WEST SUSSEX COUNTY COUNCIL CONSULTATION

TO:	Arun District Council FAO: Richard Castro-Parker
FROM:	WSCC - Public Rights of Way
DATE:	7 October 2019
LOCATION:	Land at Electricity Sub Station Ford Road Arundel BN18 9DX
SUBJECT:	AB/88/19/PL38 No residential apartments (9 No 1-bed units & 29 No. 2-bed units) along with access, off-street parking, amenity space & enhancements to the local footpath network.
DATE OF SITE VISIT:	n/a
RECOMMENDATION:	No Objection
S106 CONTRIBUTION TOTAL:	n/a

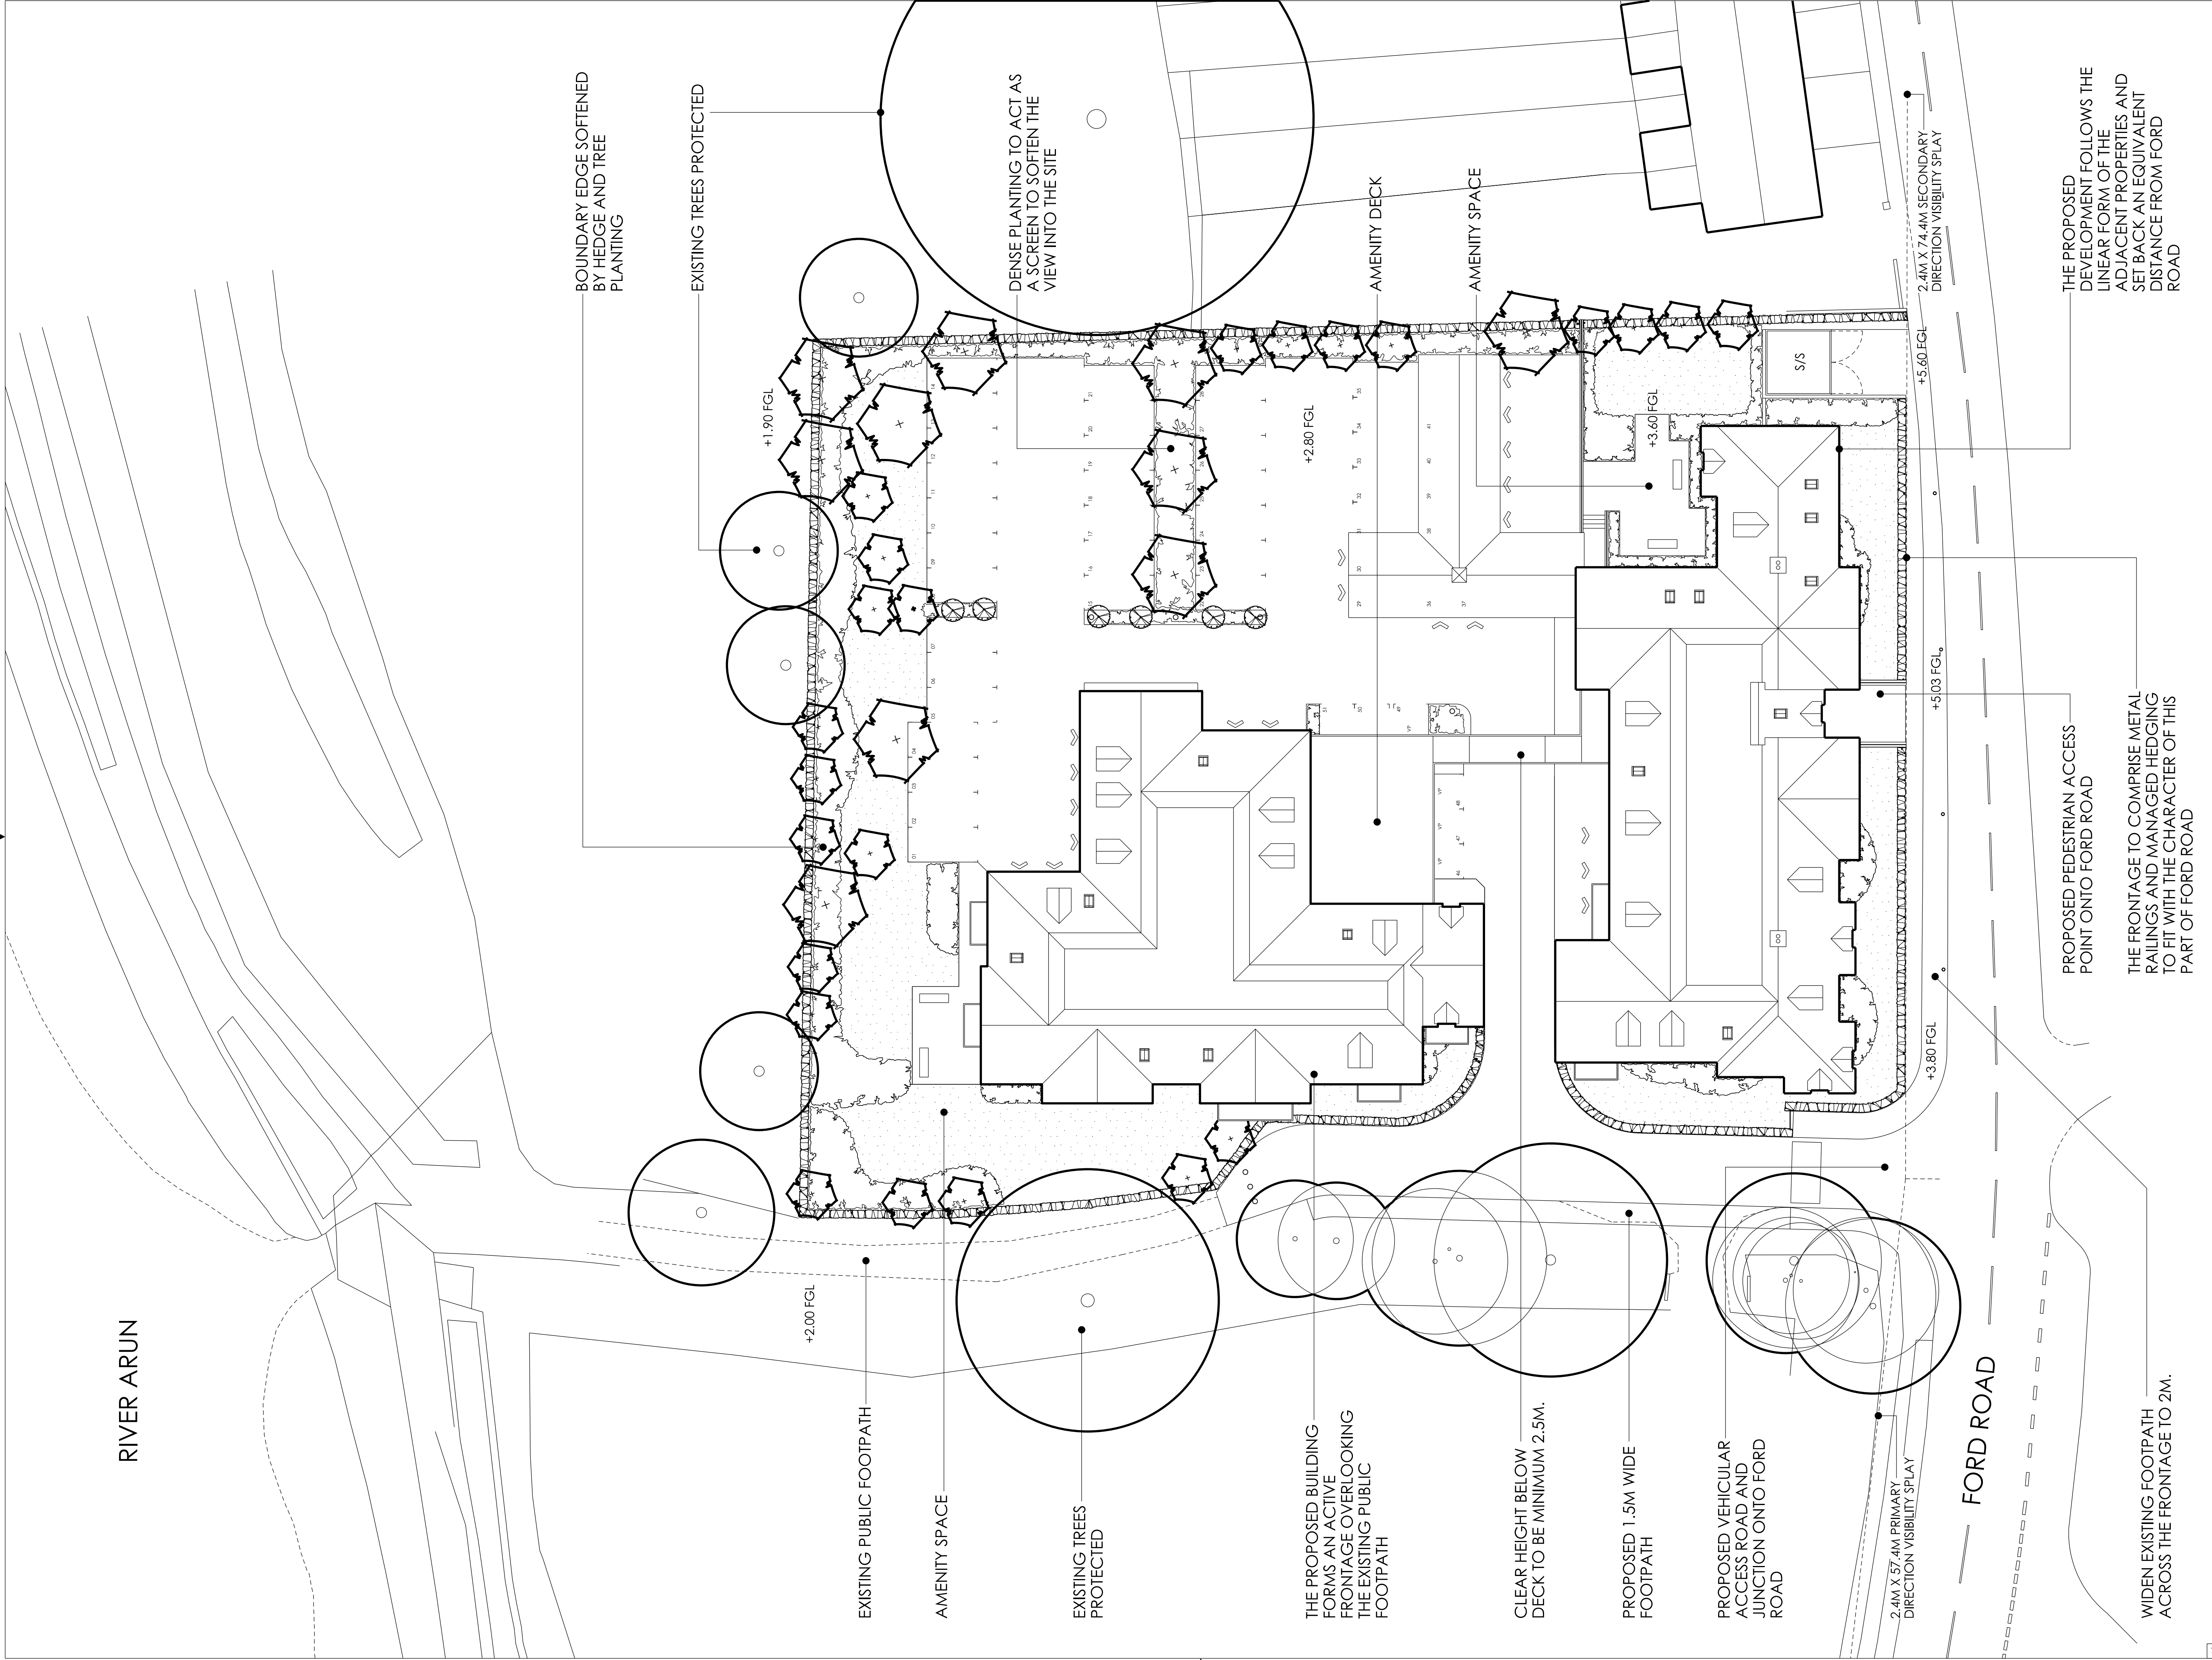
Footpath 3080 will be directly affected by the proposed development as it is proposed to be used for vehicular access to the proposed development site. It is also the link for future residents to connect to the wider PROW network and countryside as well as a link to local facilities in Arundel.

It is likely that during and following the proposed development there would be an increase in vehicle movements on this route. Where a PROW runs along a route also used for private access purposes, this shared use has the potential for accident or injury – the applicant must consider how access is managed so the public is not endangered or inconvenienced. The applicant is encouraged to introduce signage to advise vehicle drivers of the hazard and to act responsibly, including the requirement to give way to public users of the PROW. WSCC PROW team's formal consent will be needed prior to construction.

Due to the greater levels of use that Footpath 3080 is likely to experience as a result of this proposal, improvements to this path is encouraged. This should also mitigate against increased local vehicle use by establishing a cycleable route along public footpaths 3080 and 206 so as to connect Ford Road with Tarrant Street. This will benefit all local residents with a safe grade-separated means of crossing the A27, delivering benefits from a sustainable transport point of view and healthier living for residents and locals alike.

Presently Footpath 3080 is an un-surfaced route and it is recommended improvements are carried out by the Developer. Specifications for materials and widths are to be agreed with Public Rights of Way prior to work commencing. It also should be noted that:
